MEMORANDUM

To: FILE
From: Jean Fraser
Subject: Application ID: 2014-016
Date: 4/28/2014

Comments Submitted by: Marge Schmuckal/Zoning on 3/14/2014

This project is in a B-4 zone. I would like a little more detail pm the "commecial" use that is proposed. What kinds of businesses are being marketed? Each unit will need a separate permit to establish their use. The proposed use must be one of the listed permitted uses.

PROJECT PH WARREN AVENUE, LLC
SHEET TITLE SITE LAYOUT AND UTILITY PLAN

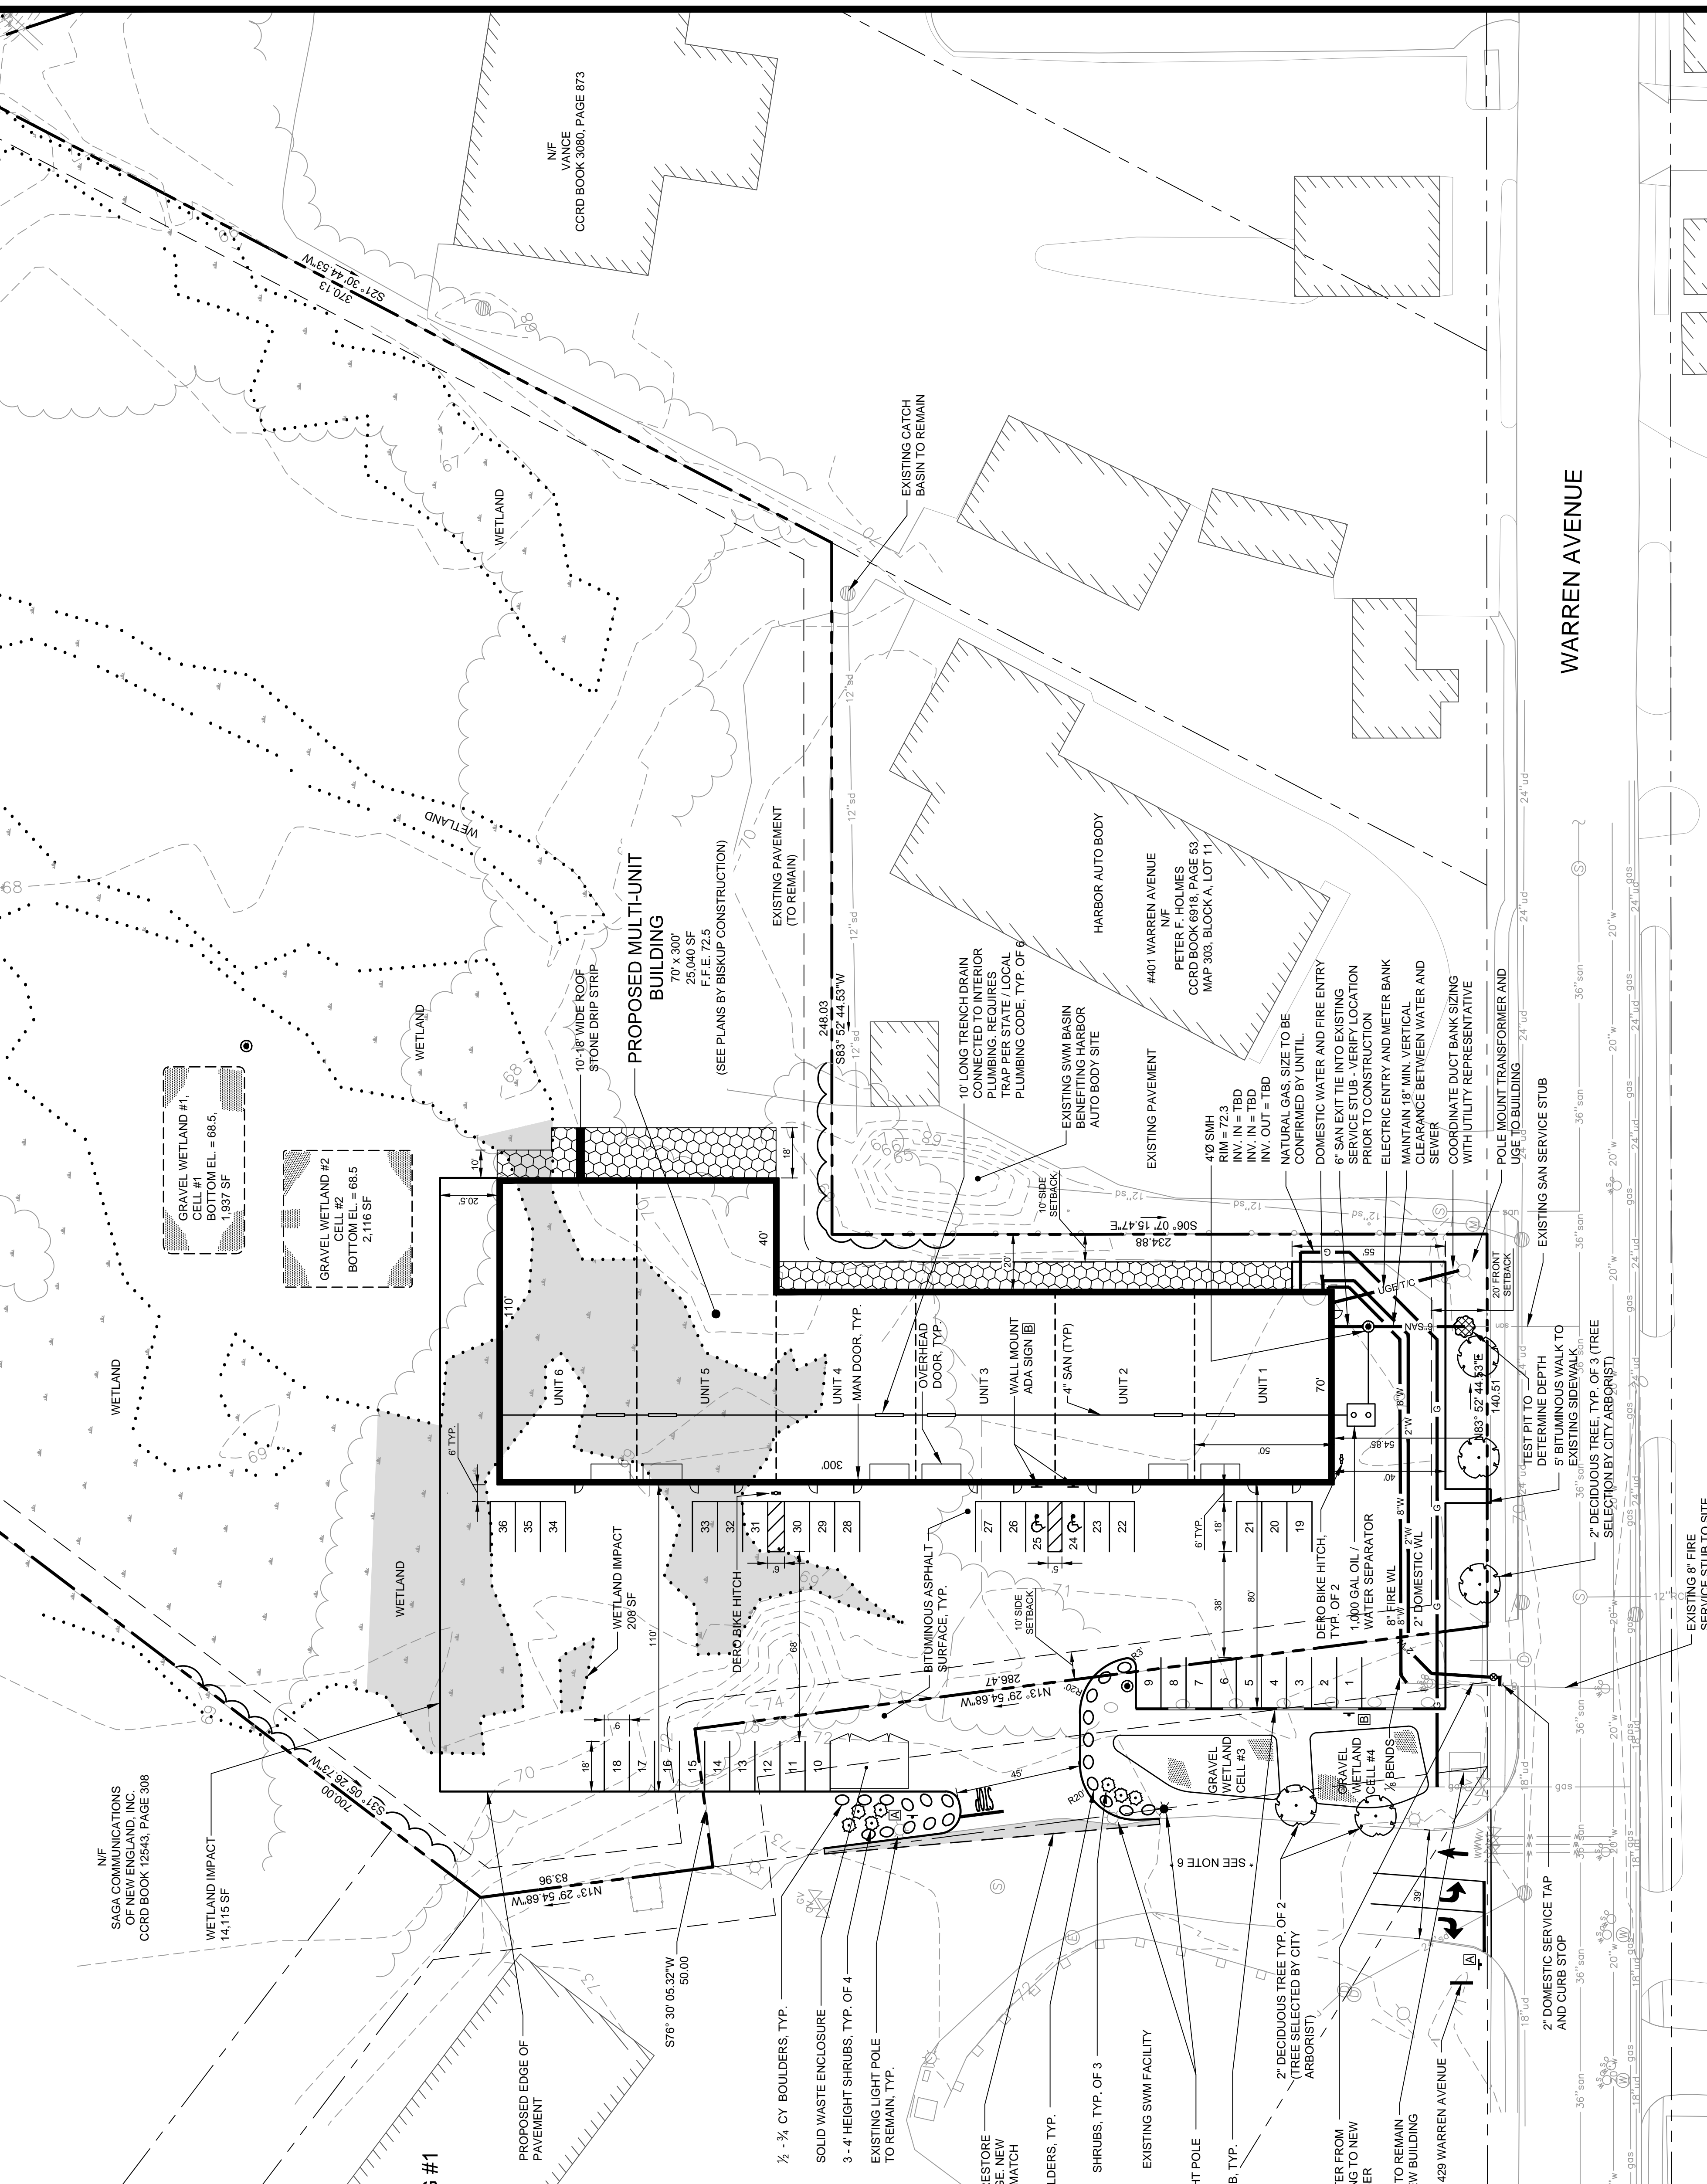
The uses affect the parking requirements. If all the uses are business, manufacturing & industrial uses, then 1 parking space per 1000 sf of floor area is required or 29 parking spaces. 41 parking spaces are shown. I do like that more than the minimum spaces are shown in case a different use is requested later. It gives a good buffer. I also noticed that 14 of the parking spaces are on an adjoining property. Hopefully there are easements that run with the property for those spaces.
